## **Development Facilitation Team (DFT) – Review Comments**

**Project No: PR-2024-010421   Date: 1/08/2025   Agenda Item: #4   Zone Atlas  
Page: G-13**

**Request: Create one new tract from two existing tracts. Proposed plat grants public utility easement along the Candelaria frontage.**

### **Application For SD-2025-00002 – Preliminary/Final Plat (Sketch Plat 6-5-24 (DFT))**

Lot line to be eliminated

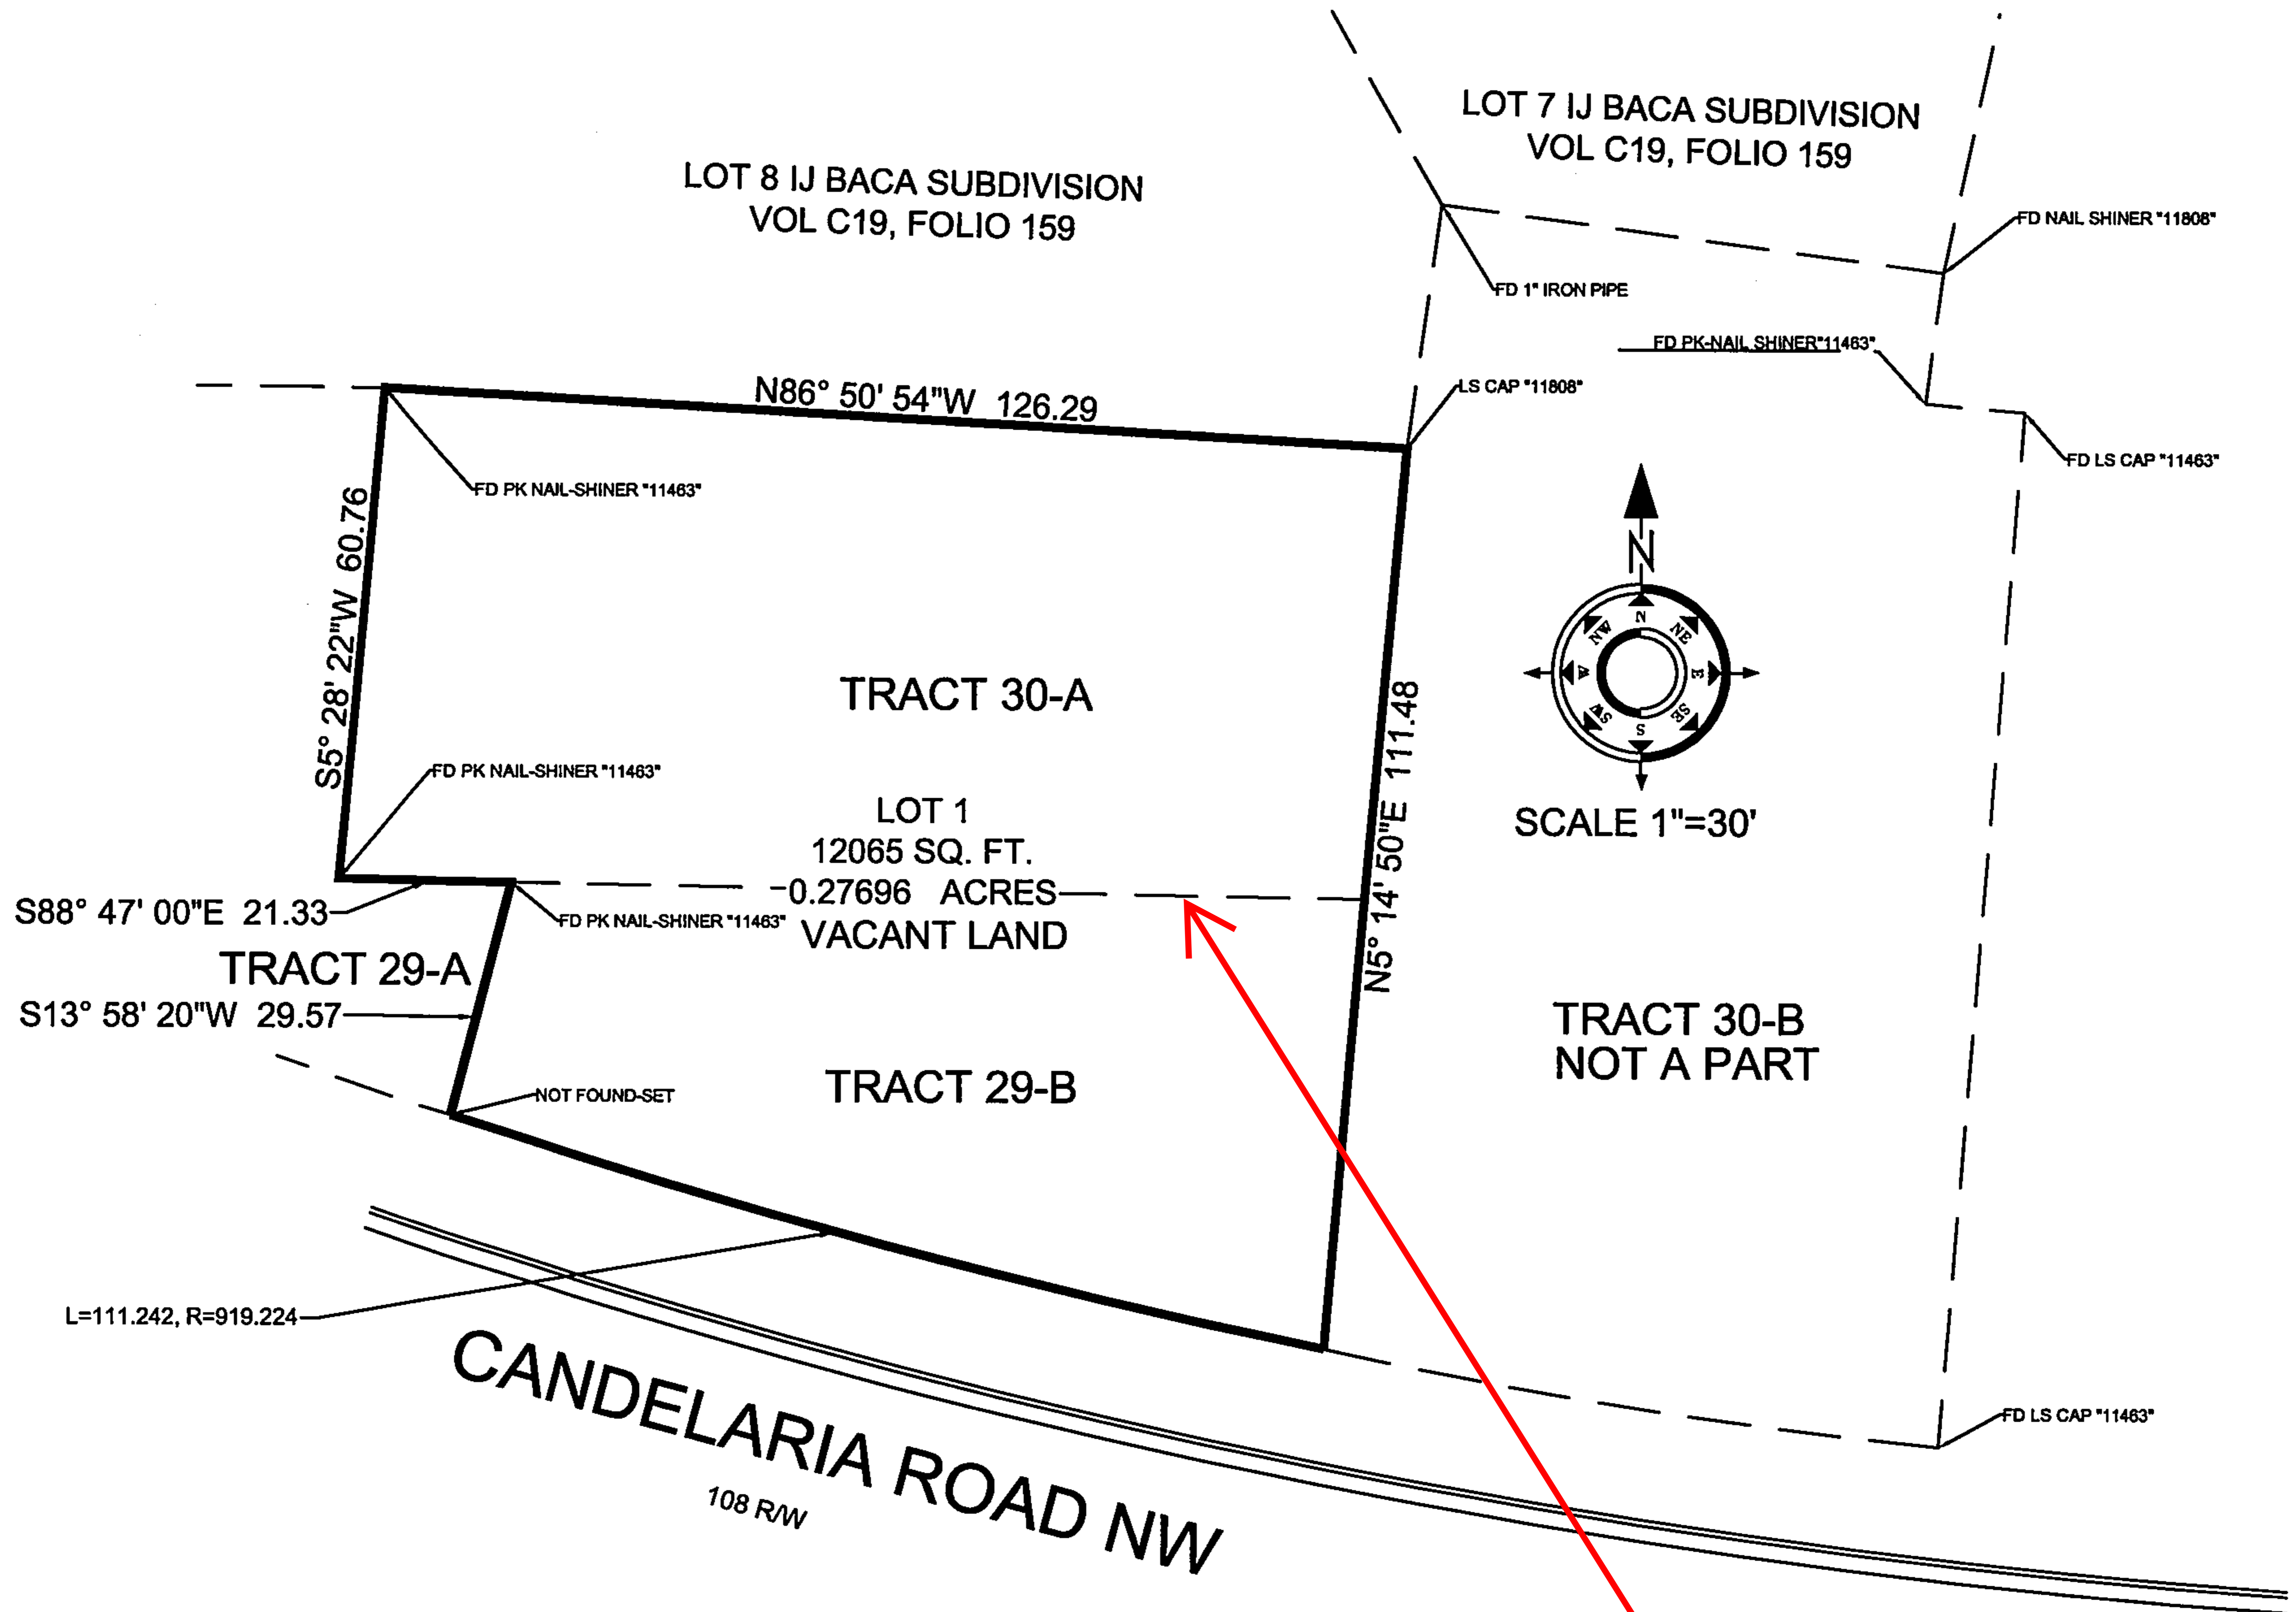
1. Based on Web GIS, there is an 8-inch vitrified clay sanitary sewer collector and a 4-inch PVC waterline somewhere along the west portion/edge of the property. The NM 811 field-locate and survey work conducted by surveyor did not pick up this infrastructure. It cannot be assumed without a complete field investigation that the infrastructure lies within the existing 30-foot private road/utility easement along Don Isidro Lane NW. If it indeed does not, additional easement is required to provide minimum widths over the actual pipe locations.

- 1. Property is zoned R-A and must meet dimensional and setback standards as per IDO 5-1(C), Table 5-1-1.*
- 2. Property is in an Area of Consistency and due to location on block, has only one lot with a structure to be utilized for comparison. However, in the Bernalillo County Assessor data, that structure and lot 30B is included with the two proposed lots 29B and 30A in the Bernalillo County Assessor's calculation of 0.53 acre. As such, it could not be subject to the contextual lot size requirements, based on the size of that lot, which is inaccurate.*

- 3. If a manual calculation of that one lot is done, based on the data presented to us, the proposed lot size of .27696 acre would closely match the remaining acreage of 2203 Candelaria (.53-.27696 = .25304), and so would be contextually consistent (within 125%).*

- The application number must be added to the Plat and the Infrastructure List.
- Curb cut and access (ingress/egress) not shown for Proposed Lot 29-B-1; please confirm where this will be located on the Plat
- A DHO Determination letter must be submitted for the DPM-required landscape buffer of 5' to 6' as the buffer is not depicted on the plat drawings.
- The AGIS office must approve the DXF file and proof of approval must be provided prior to final sign-off of a plat.
- The date of the DHO approval shall be recorded on the Plat, per 6-6(K)(2)(k) of the IDO.
